Development Single storey side extension. This application affects the character & appearance of the Craigweil House Conservation Area.

Location 60 The Drive Aldwick

I regret that I am unable to accept your documents as a formal application until the following item(s) have been received or resolved :-

SITE BLOCK PLAN 1:500

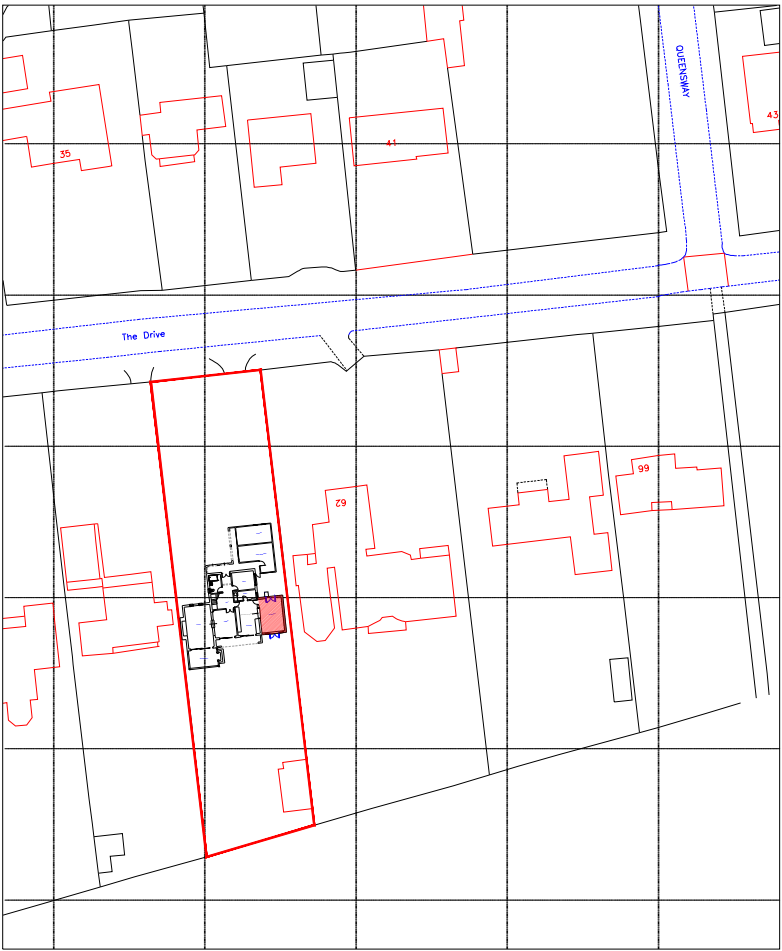
On the proposed block plan, please clearly highlight/hatch the proposed works and provide measurements from the proposal to the site boundaries.
